SSD-8777(Mod 3)
AD26/70277
DTQ:DTQ

29 July 2026

SSD-8777 (Modification 3) – MARYVALE SOLAR FARM

FIGURE 3.1
Approved and Proposed Subdivision Plan

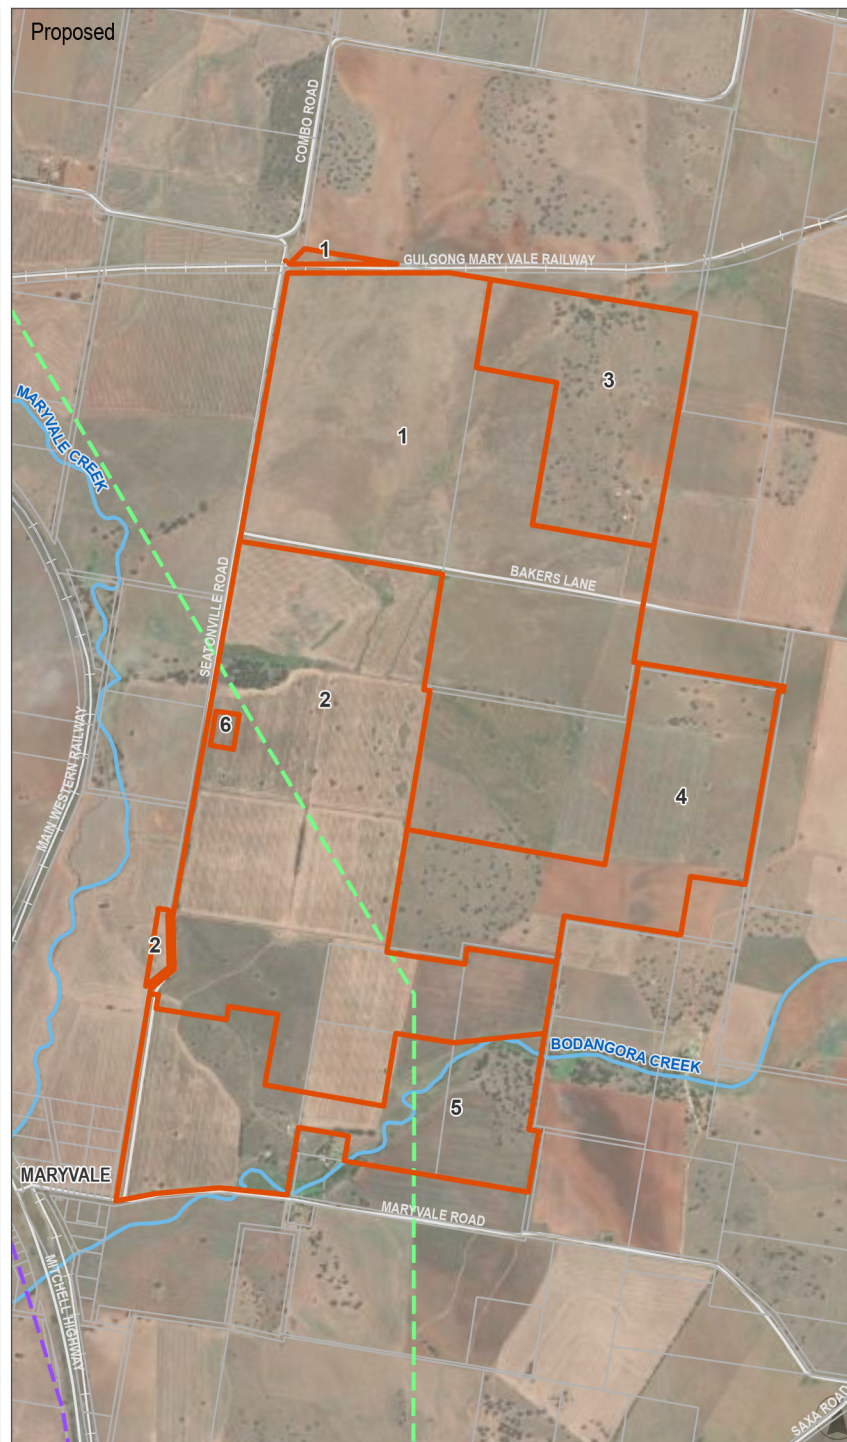
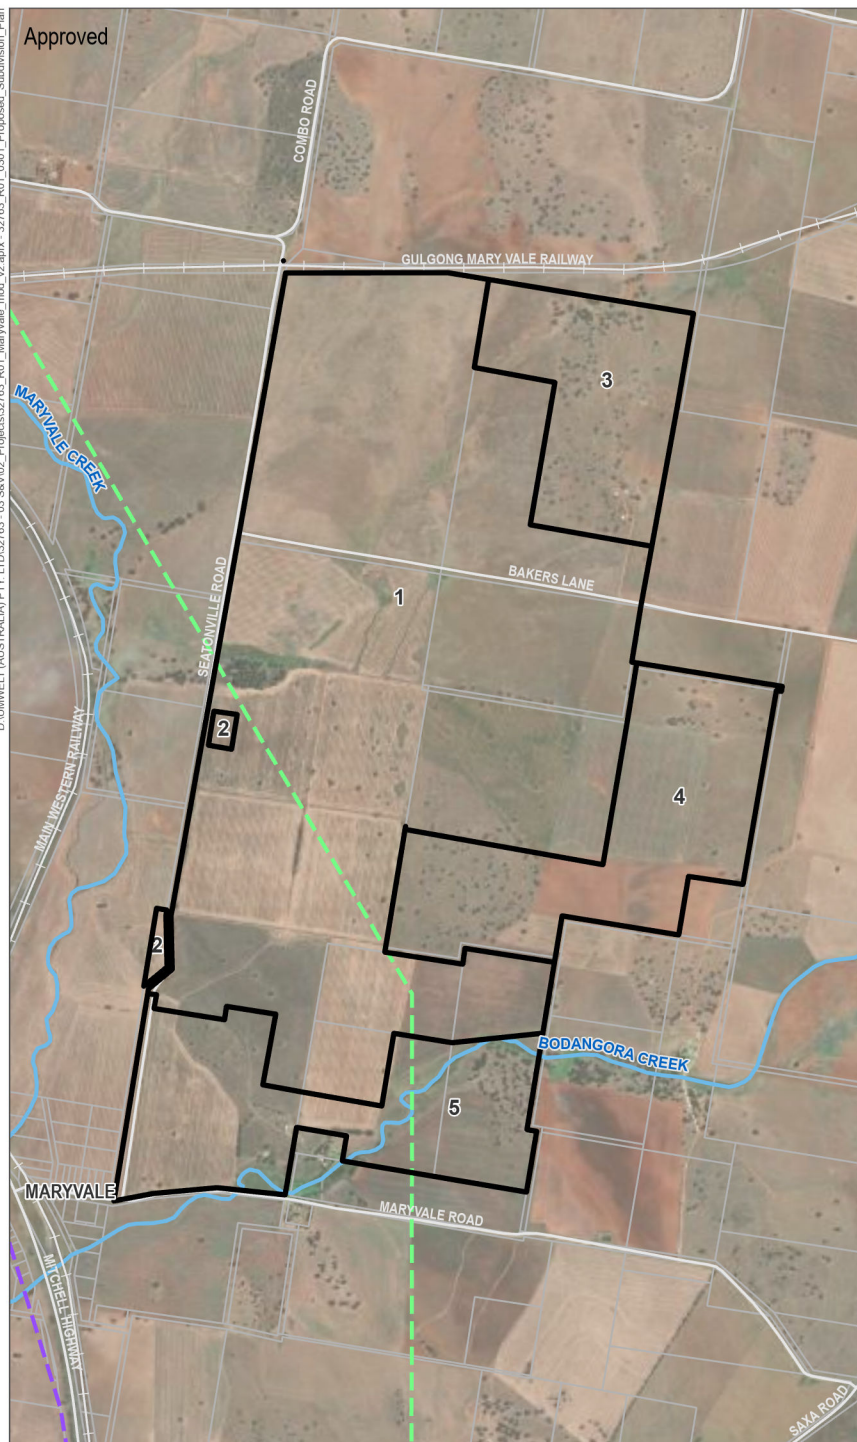
Council raises the question as to whether the subdivision of State Significant projects for the sake of land ownership and / or lease arrangements, represents orderly development.

However, raises no objections to the proposal.
